CITY OF ALBUQUERQUE

PLANNING DEPARTMENT – Development Review Services

**RE: Stanford Court (424 Stanford Drive SE)
Grading & Drainage Plan
Engineer's Stamp Date 2-9-16 (File: K16D084)**

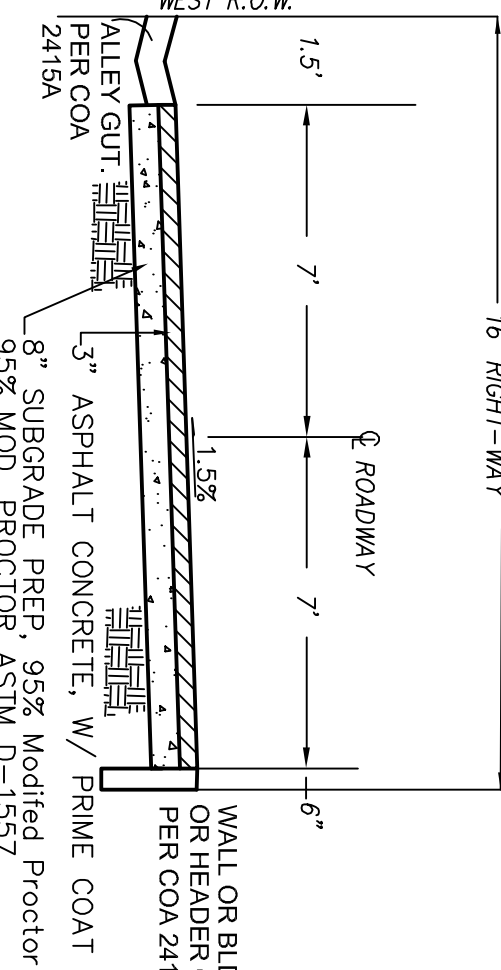
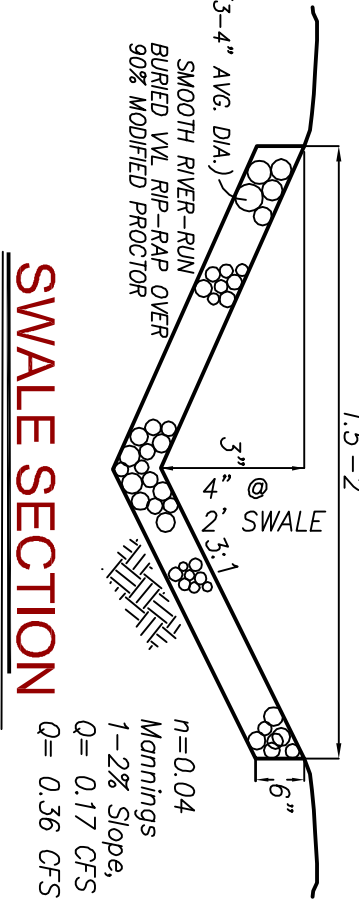
1. That the SO-19 Standard Notes are followed (attached to this letter).
2. That the two sidewalk culverts in City Right of Way are extended 6-inches behind the sidewalk.
